From: Michael Eastham
Sent: 17 November 2017 15:36
To: Planning.Responses
Subject: FW: BE/102/17/OUT

Further to the comments/queries raised by the EHO, please see comments in red below and attached.

1. The report only deals with noise in detail for Unit 2 and whilst I understand this because the application is for full permission for Unit 2 and outline for the rest of this site, I have concerns that there may be cumulative noise impacts as unit 1, 3, 6 and 7 also either be B1/B8 use and they may have associated HGV movements. I am concerned that any cumulative noise impacts have not been taken into account at this stage and wants out my permission has been given may not be fully resolvable at that point. But the applicant confirm whether they have taken this into account or not?

1A: No Mitigation L_{Aeq}

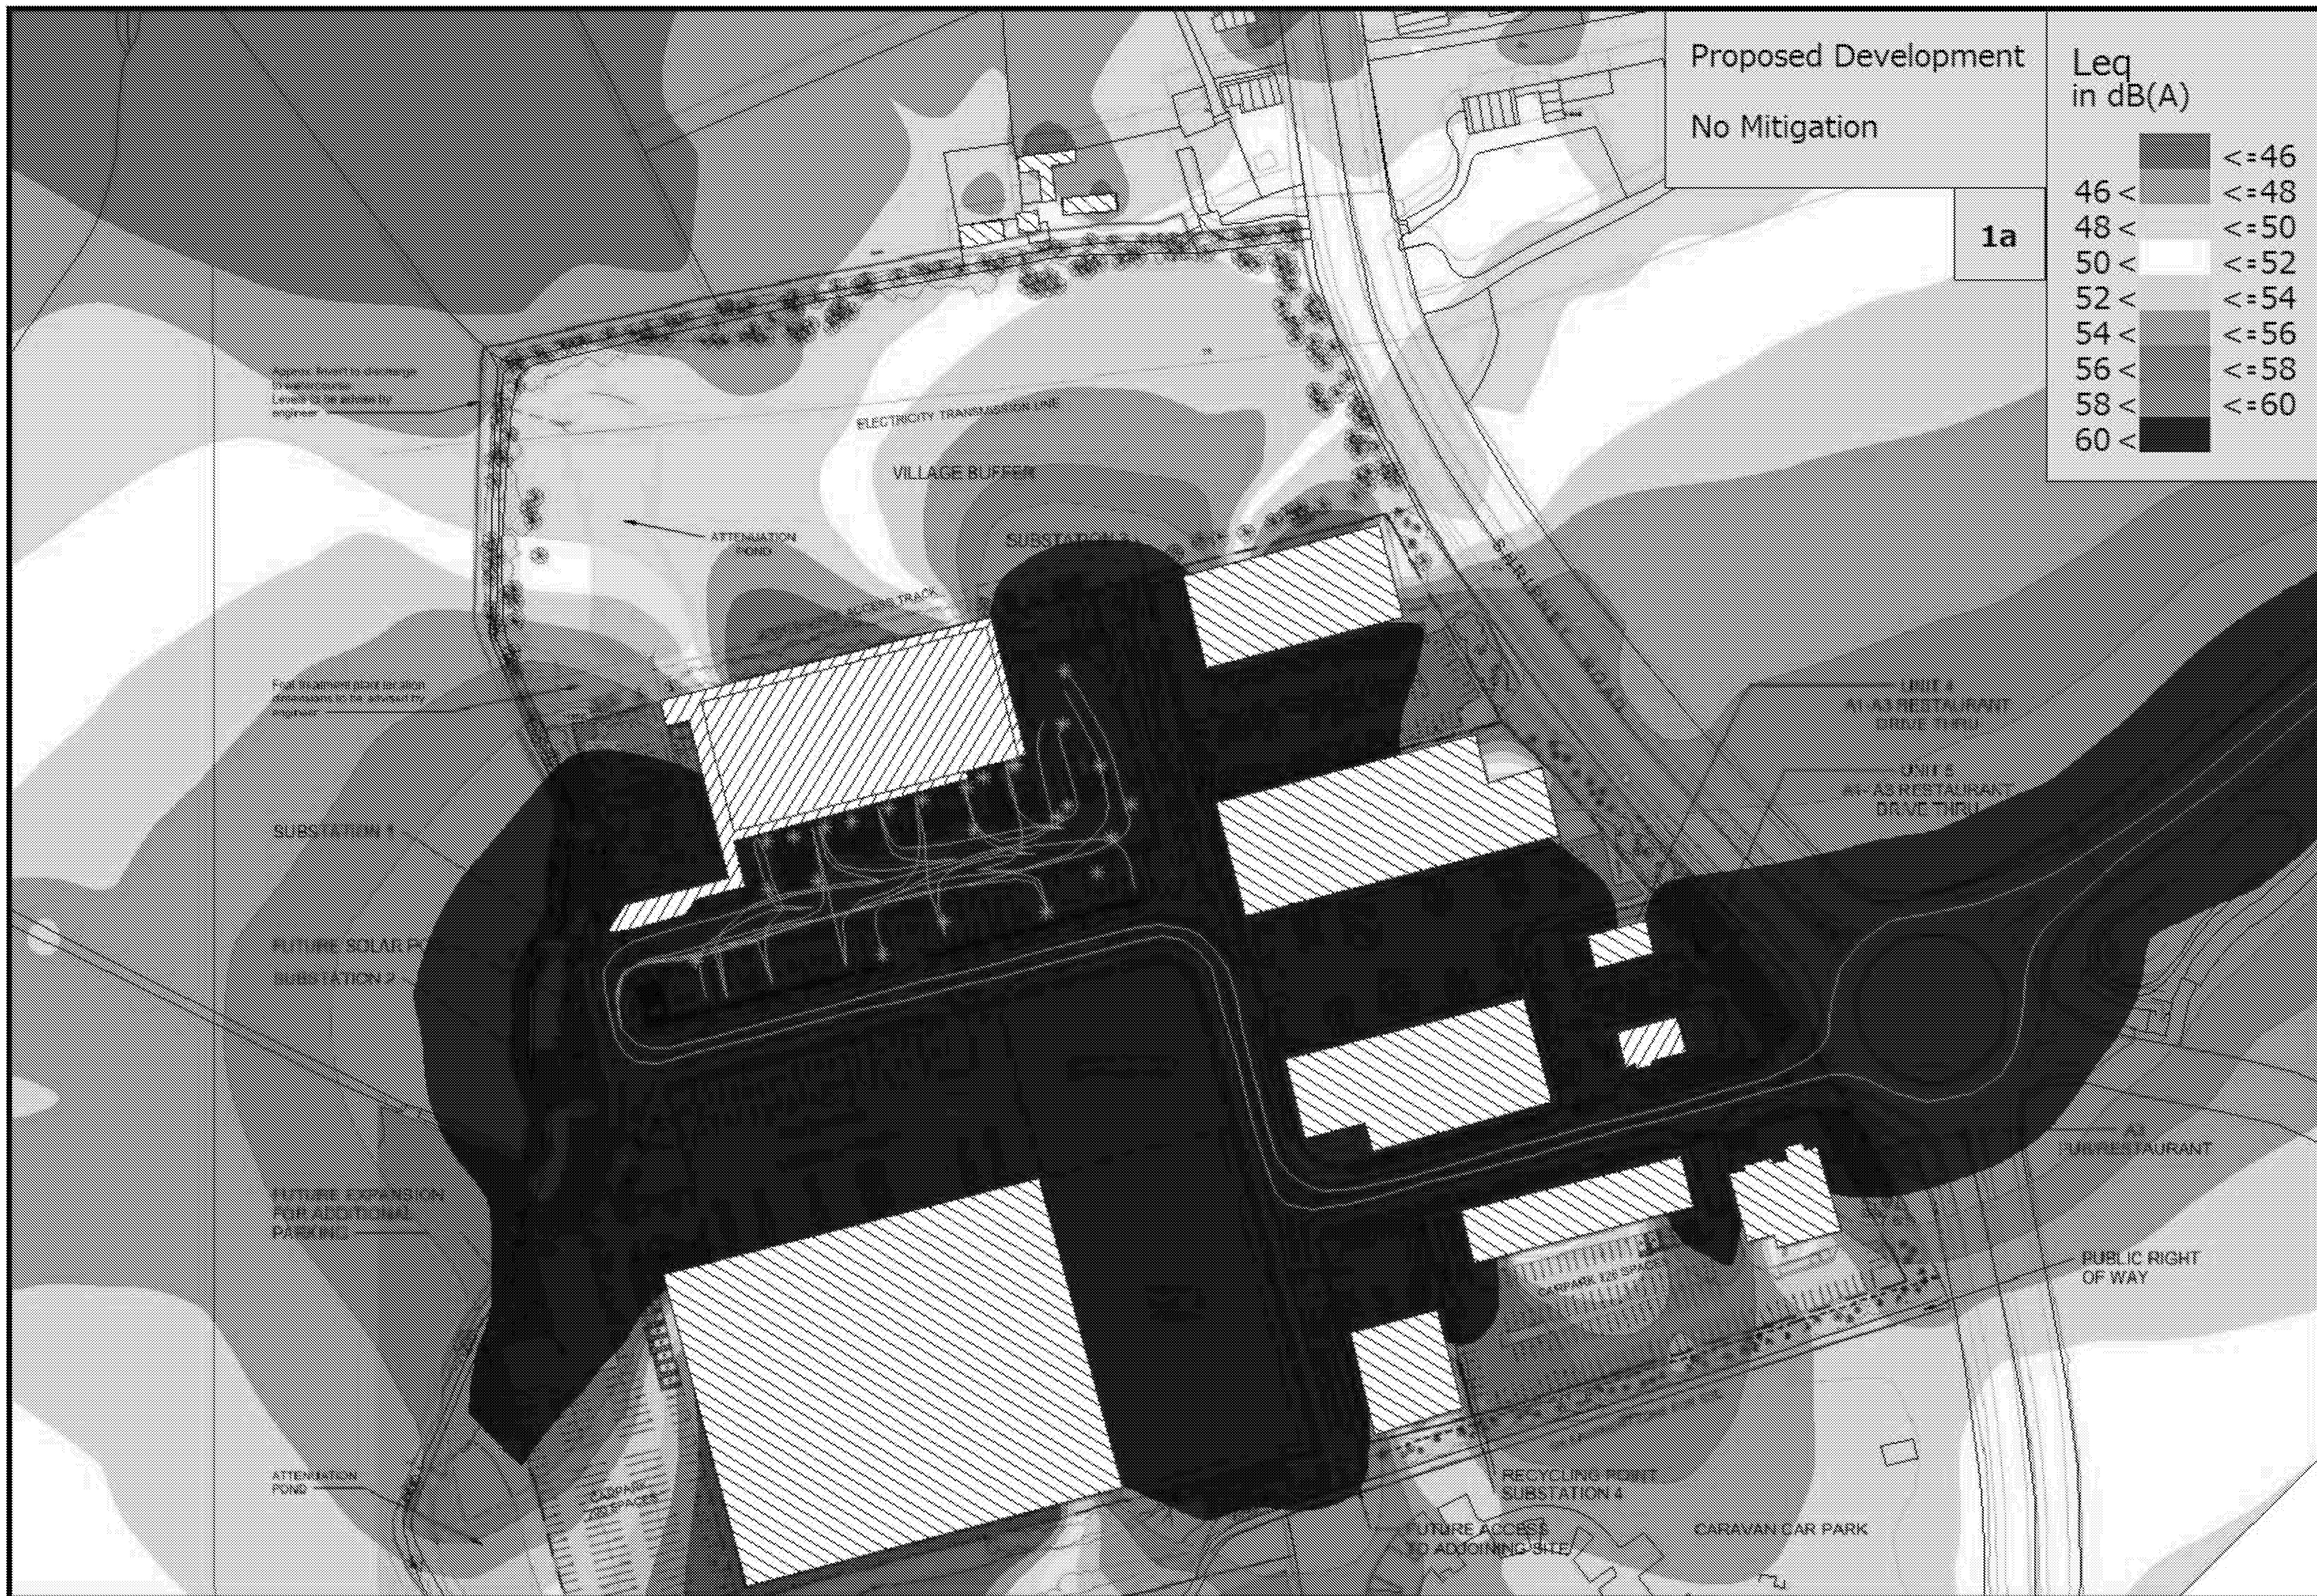
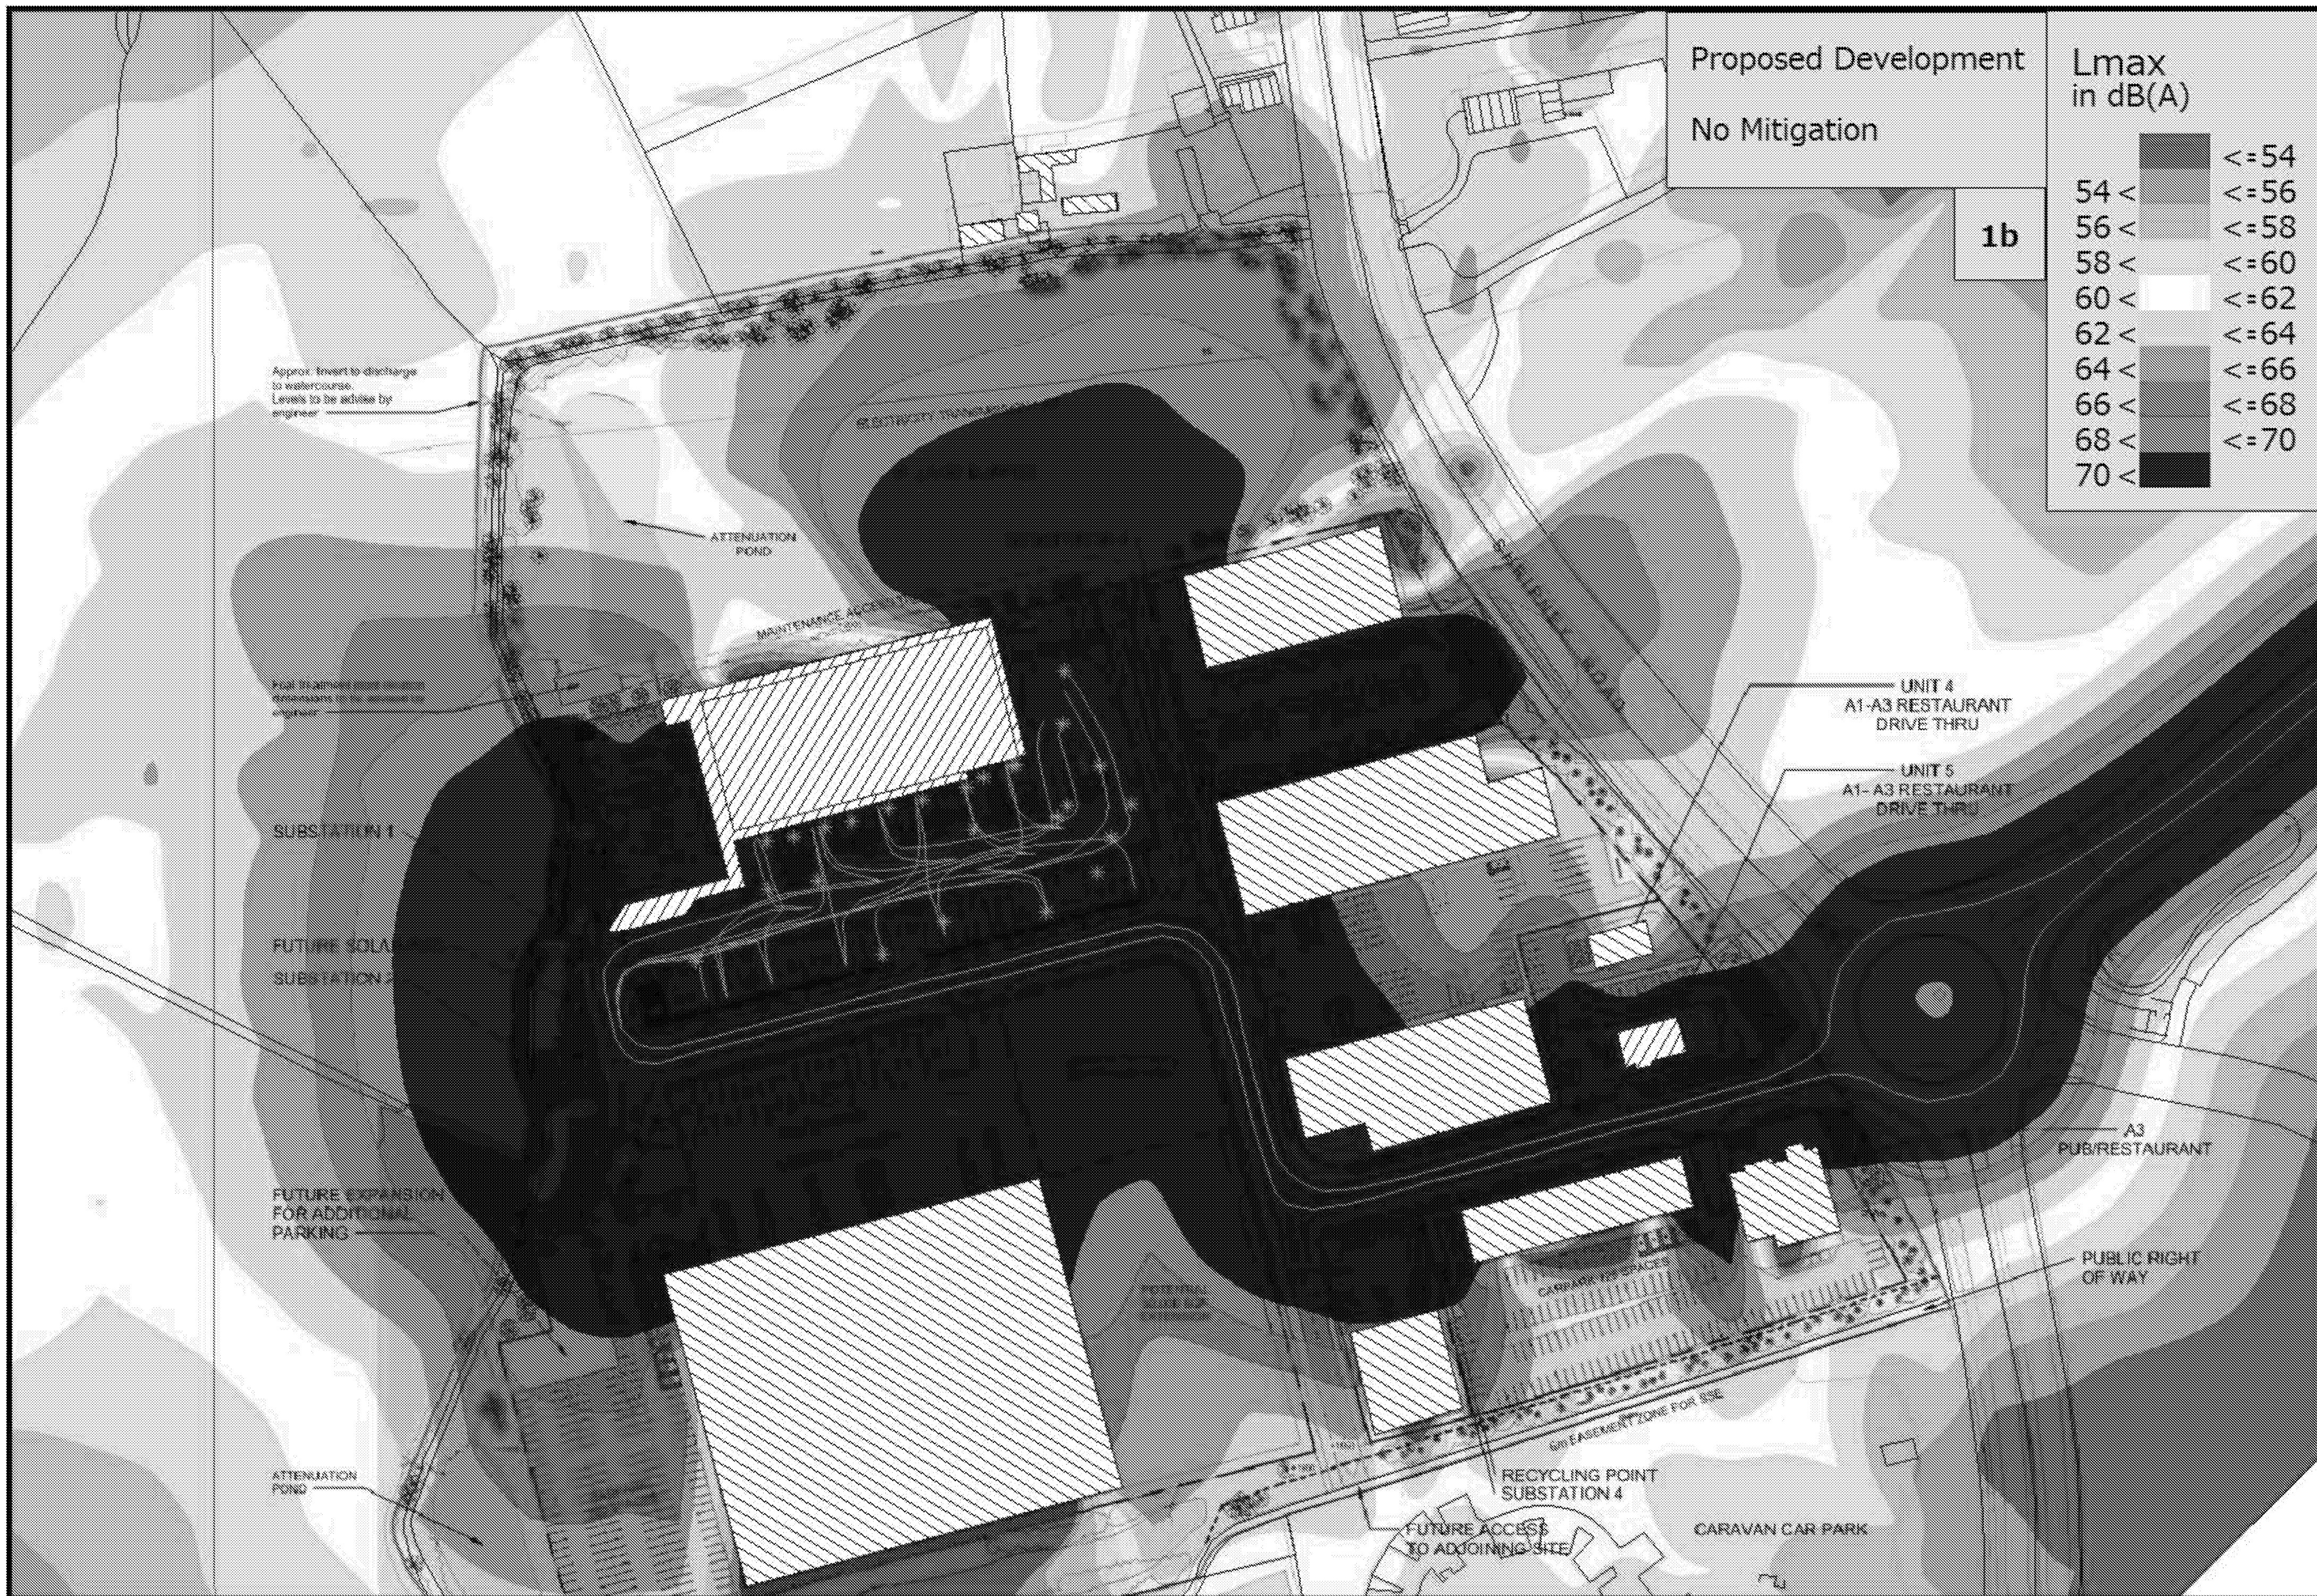
2. Please could the applicant confirm how many van and HGV movements there are likely to be in an average day time and an average night time? I appreciate that they have used data from many years worth of experience in similar situations, however surely the intensity, or not, of use will have a bearing on the resulting noise levels. For unit two I would like to know what proportion of the movements are likely to be at night time rather than daytime.

3. The report details “at the nearest noise sensitive premises”. Does the applicant mean at the facade of the nearest noise sensitive premises or do they mean at the boundry of the nearest noise sensitive premises?

4. Paragraph 4.5 on page 12, just to clarify, “all loading bays“ means all loading bays in unit two presumably?

Unit 2 was assessed as the only full application. There is no detail relating to the future use of other units, although the assessment was modelled using worst case of all loading bays being operated simultaneously. Any future HGV movements across the site would need to double to give a 3dB increase. Even with this unlikely level of activity the L_{Aeq} levels at the nearest residential property to the north would be in the region of 51dB and still be within desirable WHO guidelines for external noise. Any L_{Amax} levels would be consistent with predictions.

The proportion of day/night movements are not known at this stage and would be operator led. The predicted modelled levels use worst case scenario of all loading bays operating simultaneously at full capacity to provide robust assessment

SoundPLAN™ modelling software predicts to the façade and takes this into account.

All loading bays in Unit 2
